From: [REDACTED]  
Sent: 16 January 2024 11:06  
To: Tom Nemeth  
Subject: [EXTERNAL] RE: Planning Application: SB/23/02713/FUL  
Attachments: Fig 4. Scaled elevation and floor plans.v3.pdf

Ref Planning Application: SB/23/02713/FUL

In response to the invalid application response for the proposed swallow-nesting structure at Marina Farm, Emsworth, please find attached reply to further clarify the requirements for re-submission of the application.

MARINA FARM GAZEBO: PROPOSED FRONT, REAR AND SIDE(S) ELEVATIONS

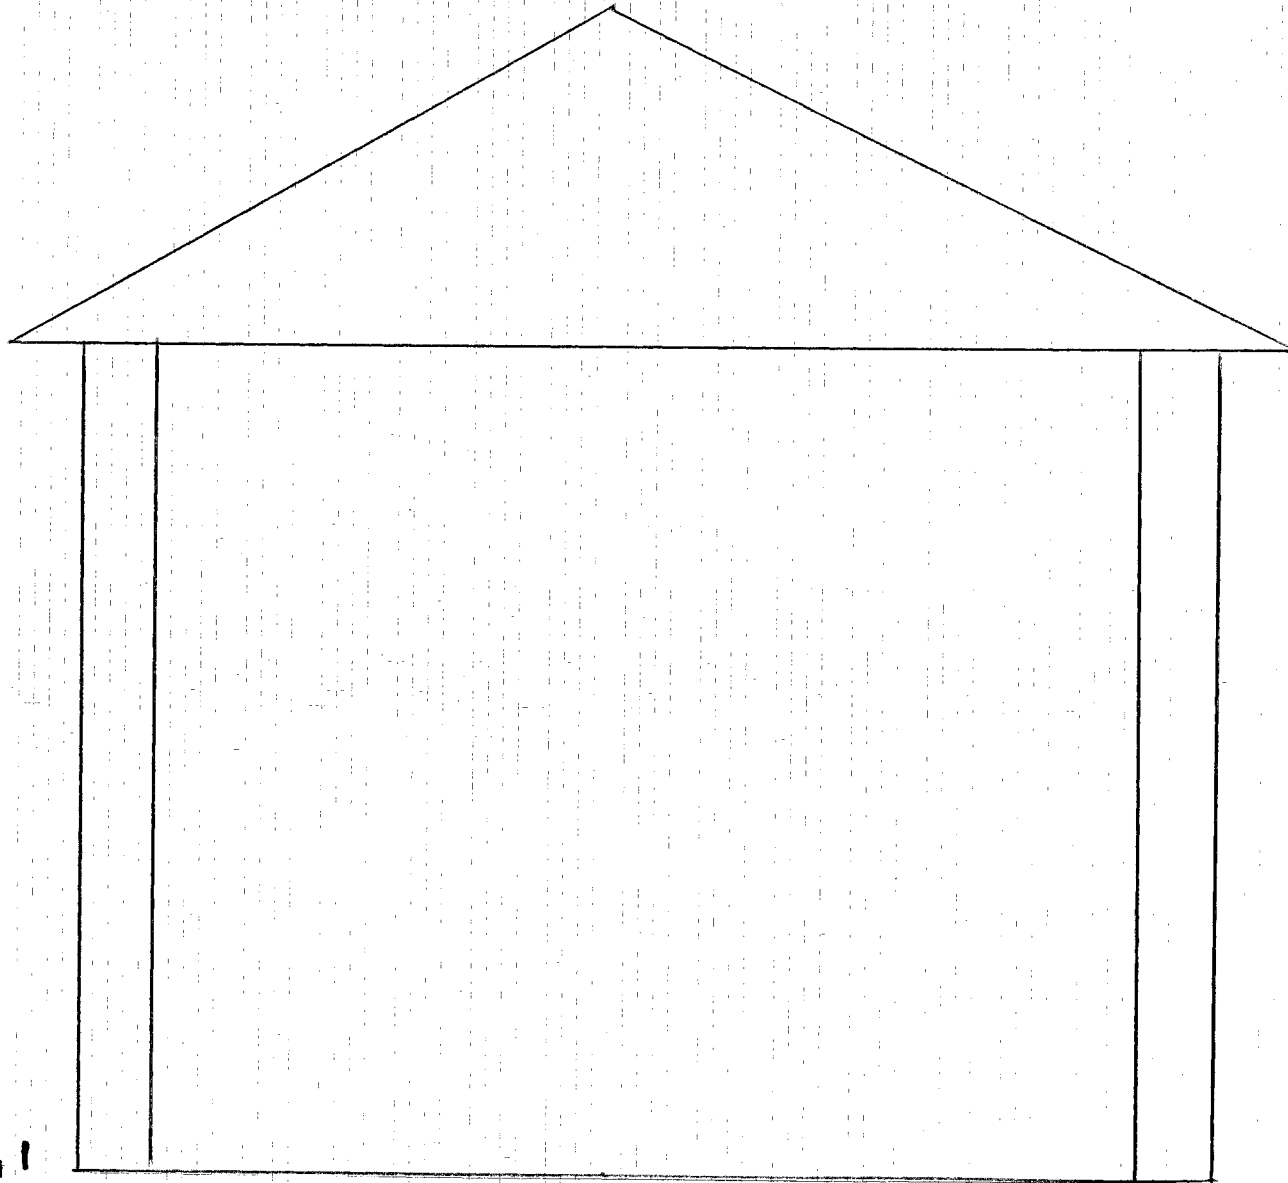
The title of the Elevations is barely viewable/legible. Please redo!!

The drawings are fine and tick the validation box but for clarity could you please amend the elevations title to include sides ie Proposed Oak Gazebo Front, Rear and Side(s) Elevations, and resubmit.

Dear Tom,  
I have re-drawn the elevation plan with title – please find attached. I will re-submit via the planning portal.
